## Department of Transportation

US-024G and Stapleton Road  
El Paso County

RE: Waterbury Filing No. 1  
Final Plat (SF237)

WATERBURY FILING NO. 1
CONSTRUCTION SET
WEST CHANNEL - CHANNEL IMPROVEMENTS PLAN

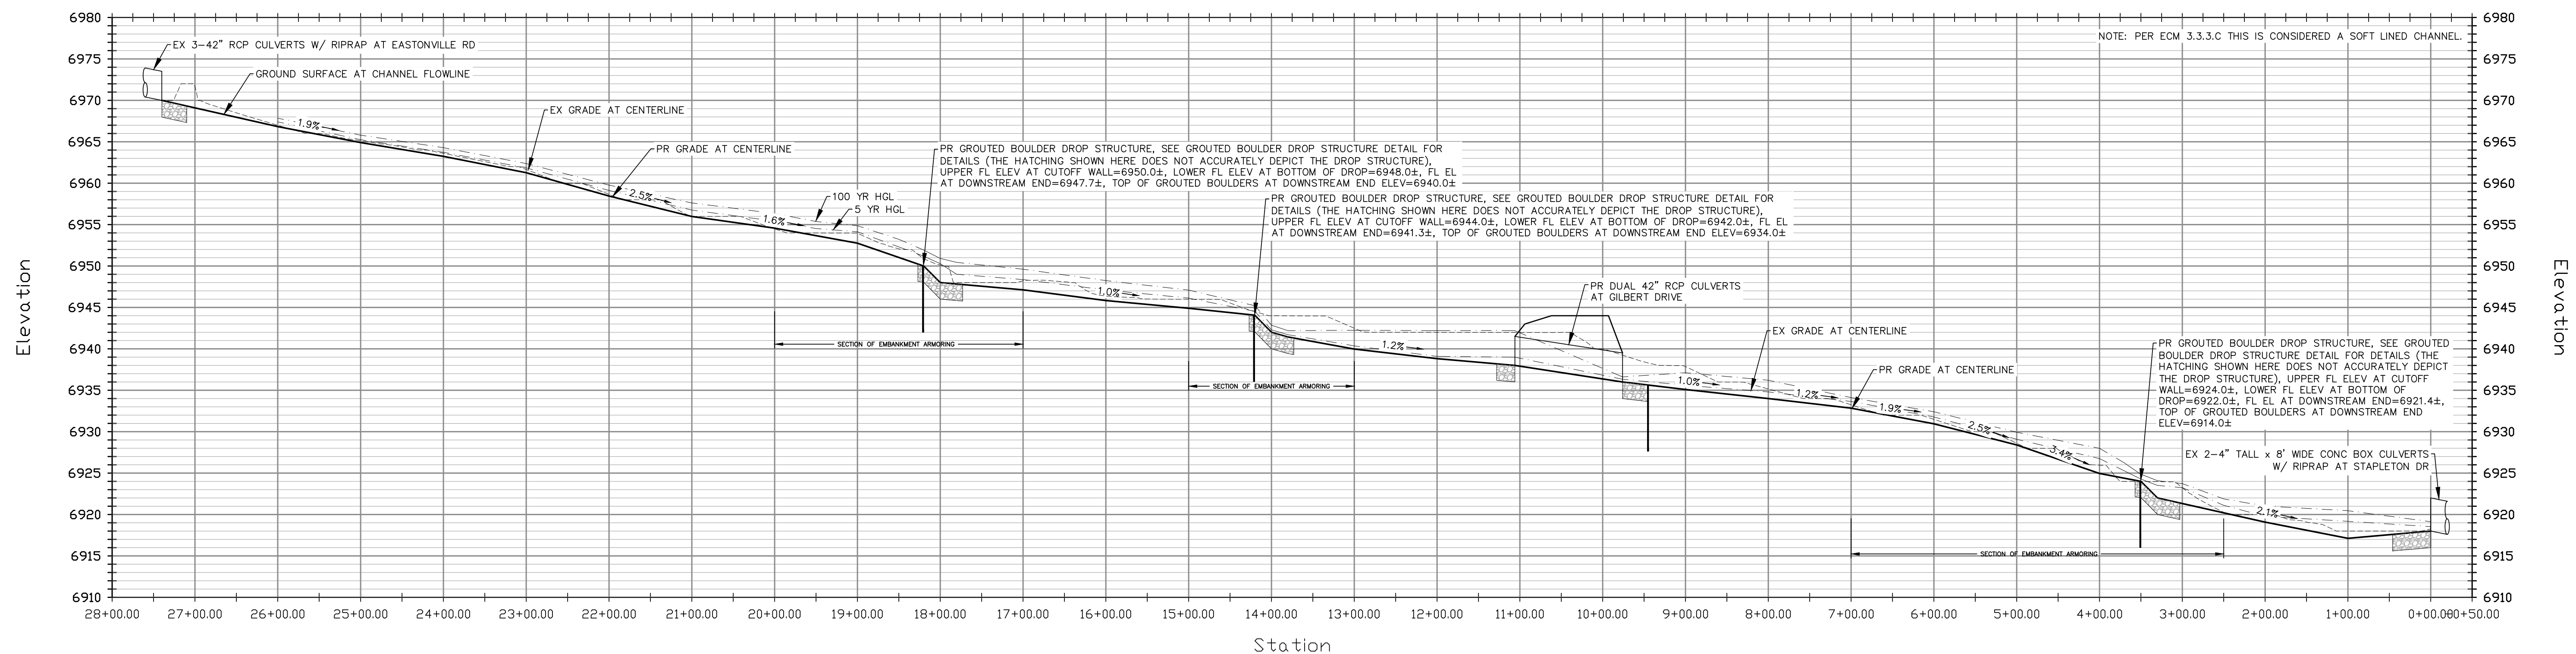
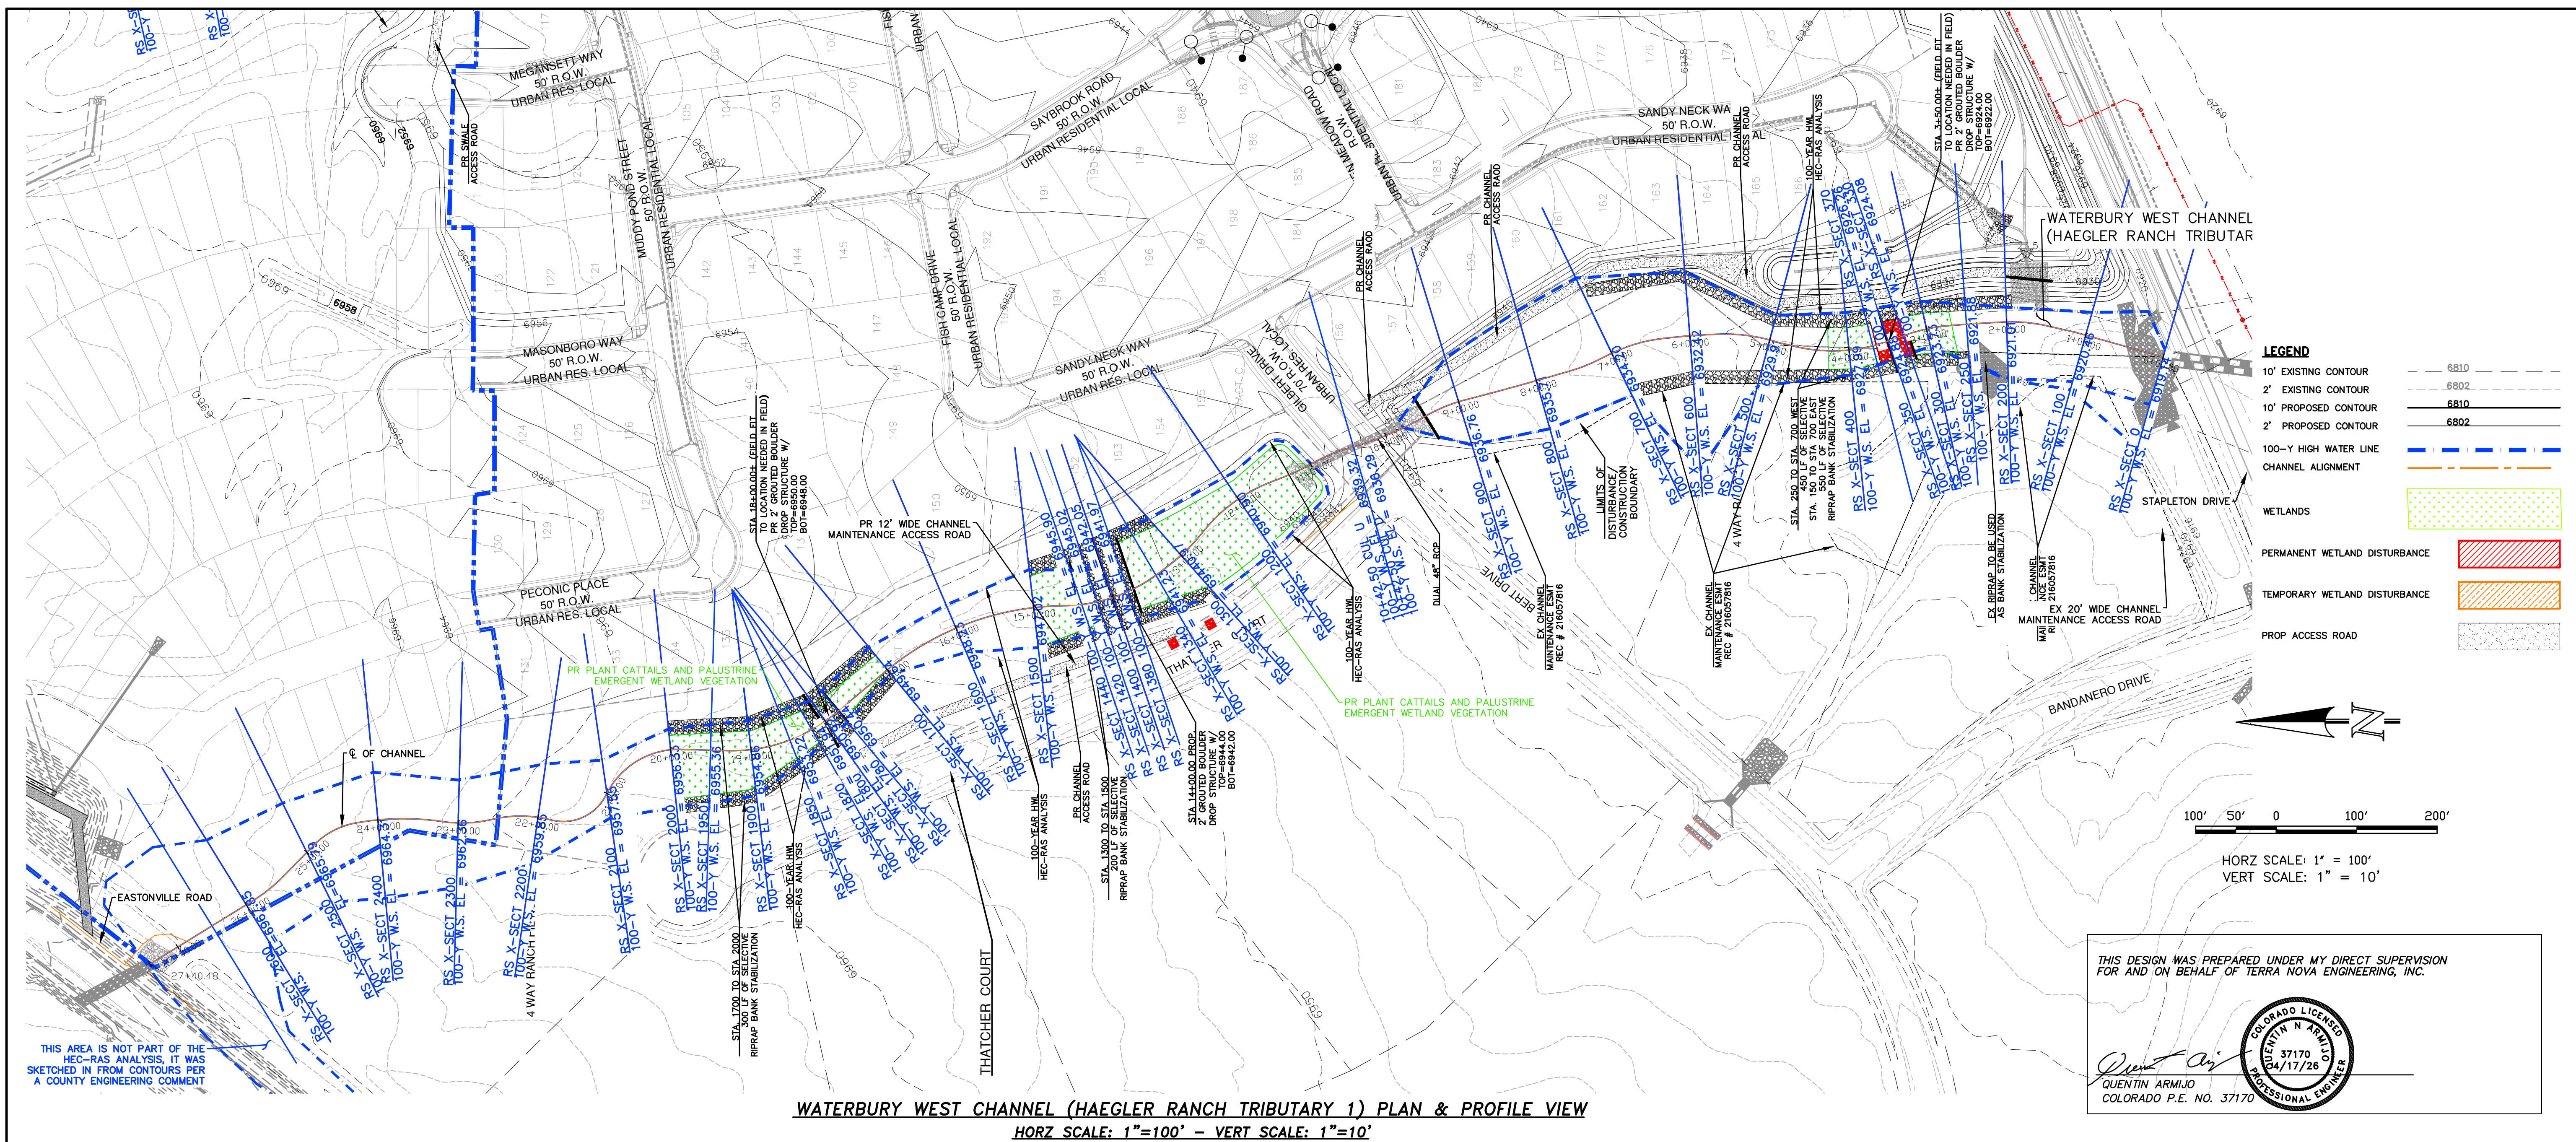
- Report Comments
  - **Repeat comment:** The HEC-RAS model does not appear to account for the pond overtopping scenarios (100% of 100-year flows passing through emergency overflow). Potential downstream impacts of the proposed ponds to CDOT facilities are unclear.
    - A peak flow of 188 cfs was used for the East channel analysis. The peak inflow is 269 cfs, and the peak outfall in the 100-yr event is 37 cfs. If the spillway is utilized, an additional 200 cfs will be realized into the channel directly upstream of CDOT facilities.
    - Do the channel and the US24 culvert have capacity for this scenario?

Address the hydraulics comments above and resubmit documents as necessary.
